From: [REDACTED]
To: [Metrowest1](#)
Subject: Issue Specific Hearing 2, Day 1, Agenda item 4 - Permanent Public Right of Way Diversions and Alternatives
Date: 11 January 2021 22:08:41

Pill & Easton-in-Gordano Parish Council

**ROYAL PORTBURY DOCK ROAD
EQUESTRIAN UNCONTROLLED
CROSSING**

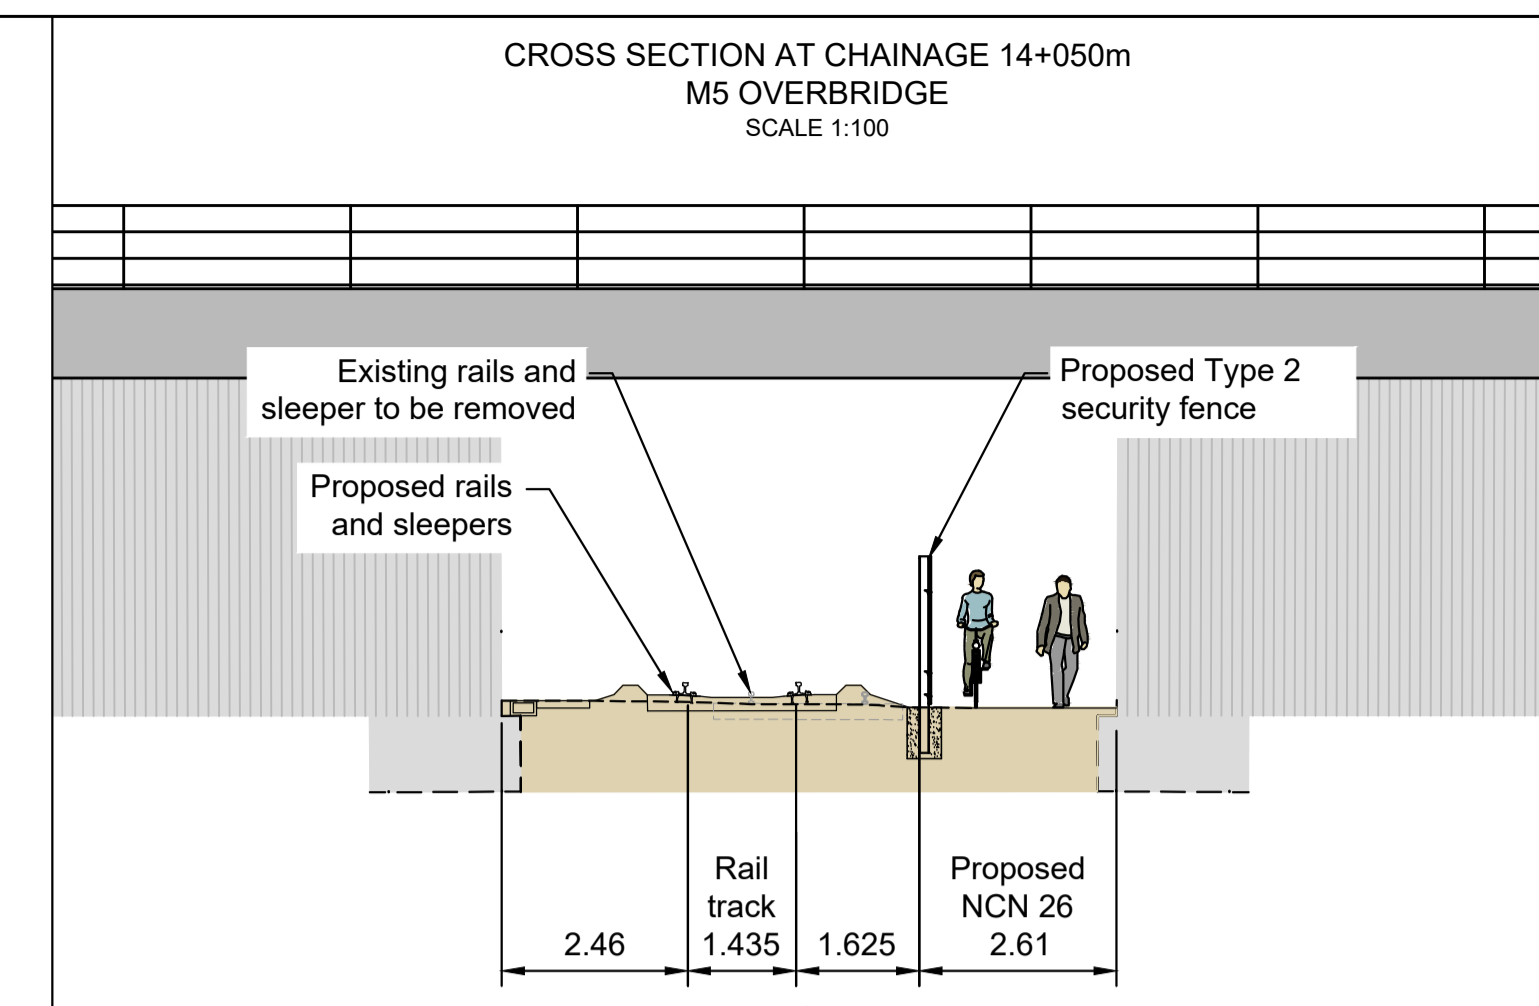
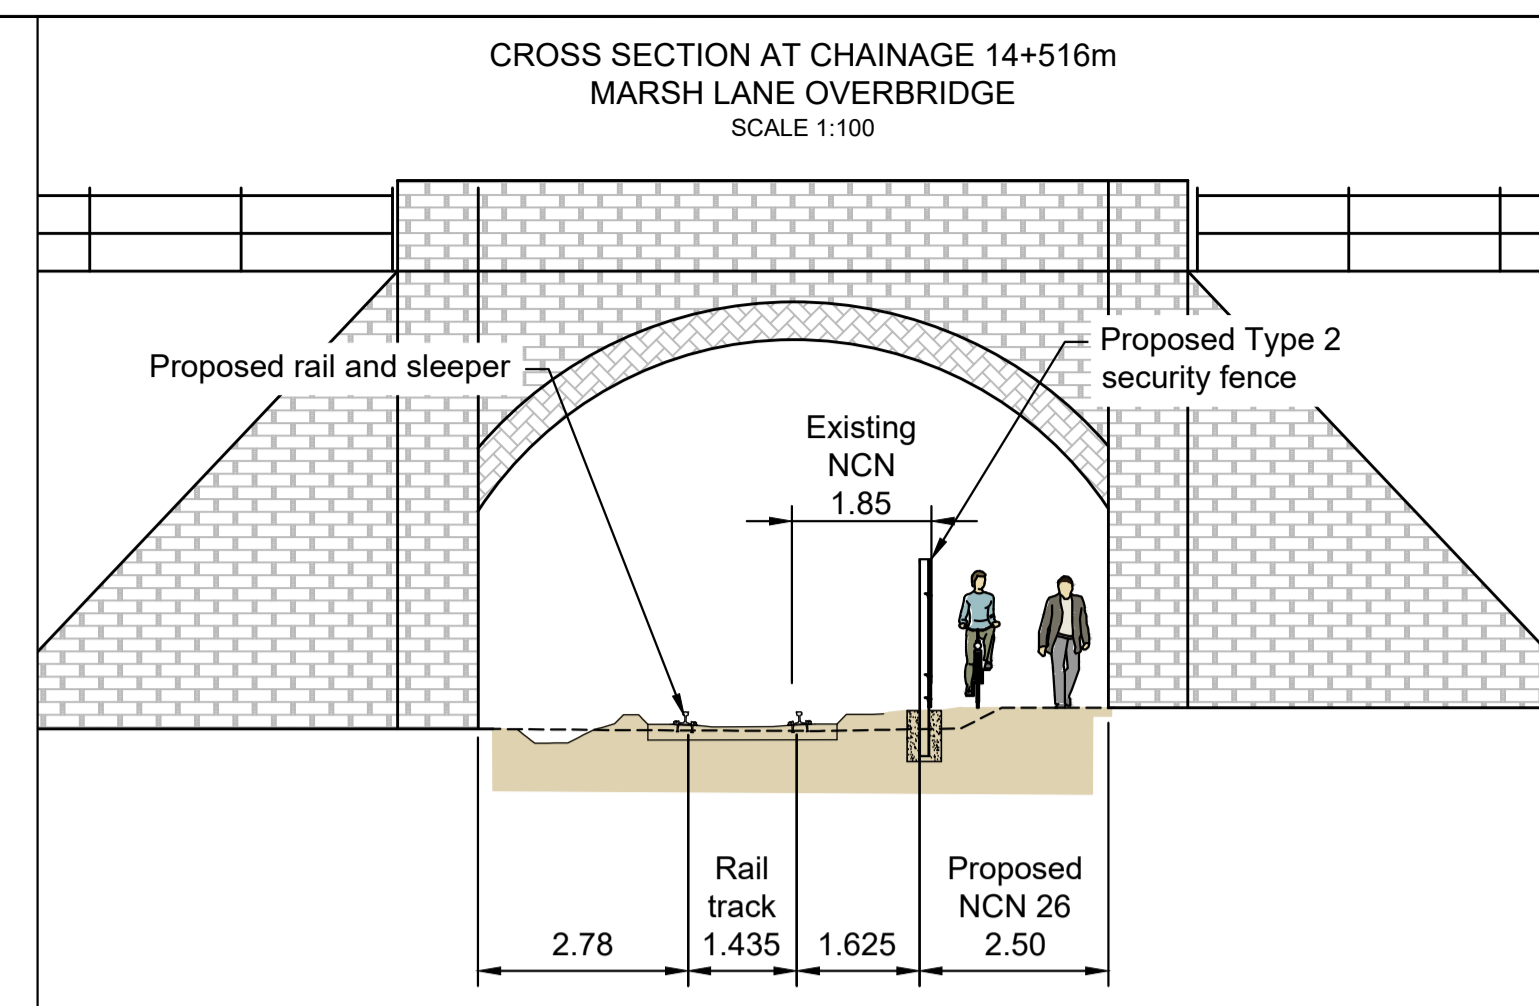
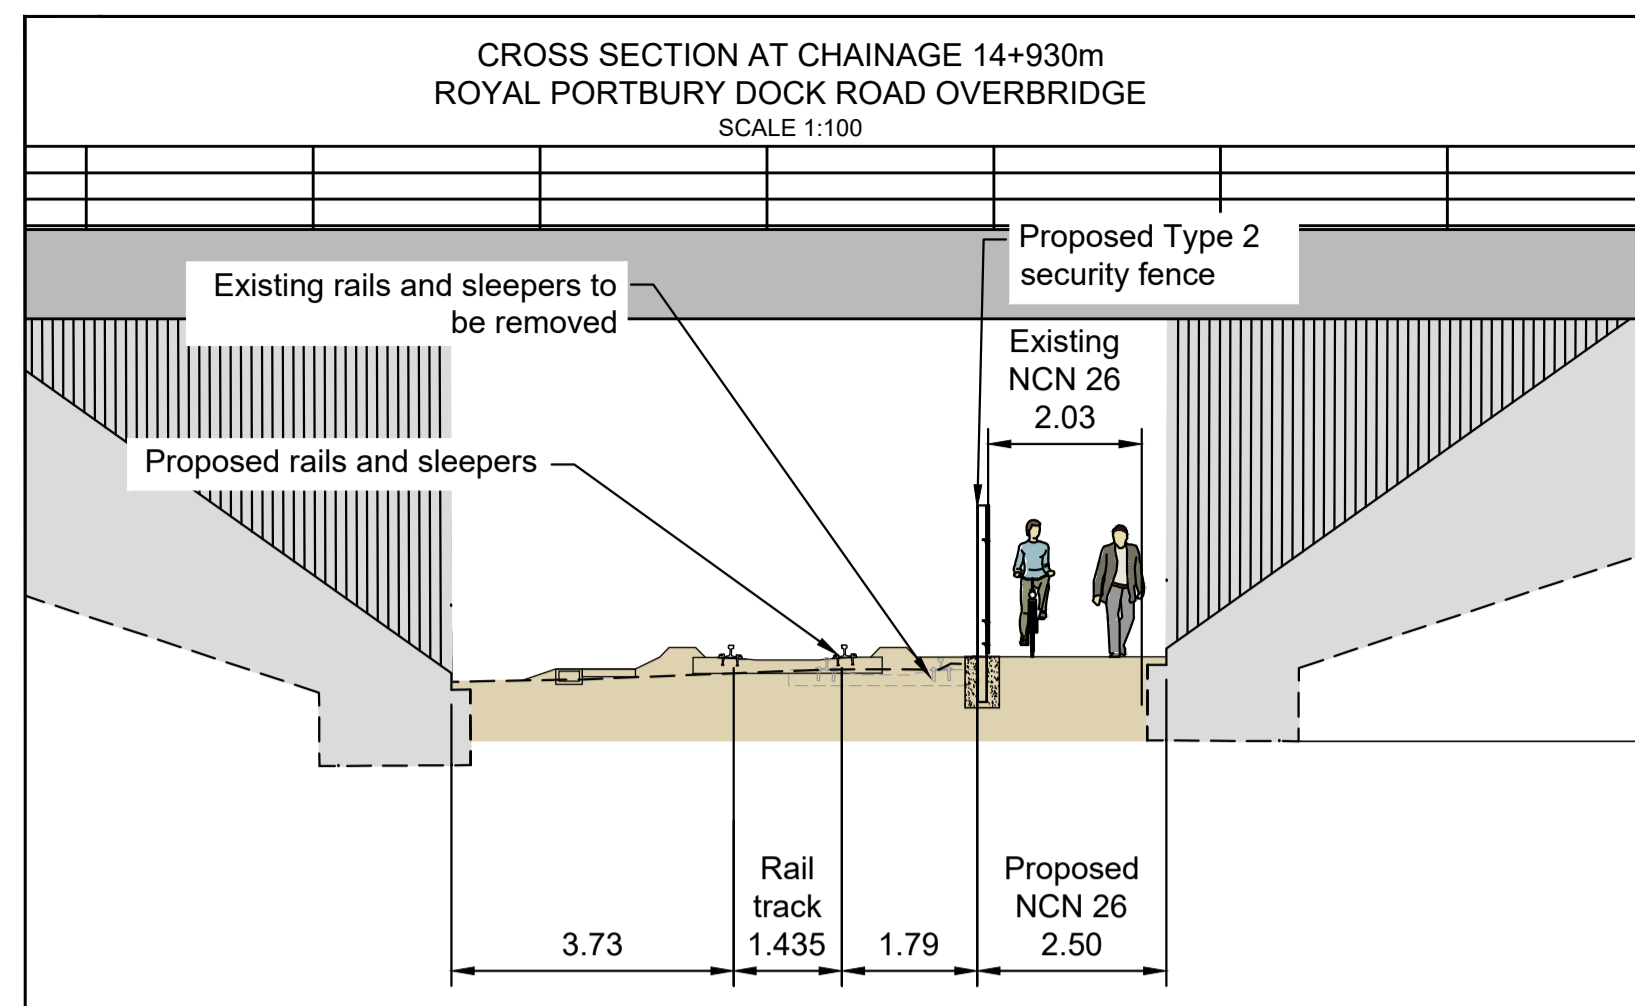
1. Bridleway Crossing Royal Portbury Dock Road. Mr Berry spoke first and raised his concern about providing a bridleway at road level to cross Portbury Dock Road. Although he thought that the posted speed limit was higher than the actual 30 mph, I concur with him that vehicles frequently travel much faster along this stretch of road. I know because I use it several times every week as my preferred route between the M5 or and my home in Easton-in-Gordano. Therefore, I share his view that providing an uncontrolled crossing on this road would invite a serious accident. I don't think I've ever seen a pedestrian or horse attempting to cross this stretch of road in the past nine years and with good reason. It is very wide, sometimes busy with HGVs and lighter vehicles, occasionally exceeding the 30 mph limit by a significant margin, so crossing on foot or with a horse, would be potentially very hazardous, unless the traffic was brought to a halt. Also, I walk and cycle along NCR 26 fairly often, although not as frequently as Mr Berry, and I also have never seen a horse on it. I entirely agree with the objective of providing a route for horse traffic that avoids the need to pass under the Portbury Dock Road overbridge close to the live tracks. However, unless pedestrian/rider controlled traffic lights are provided for the crossing, I believe that it would be extremely dangerous to encourage horse riders (or pedestrians) to cross that road.
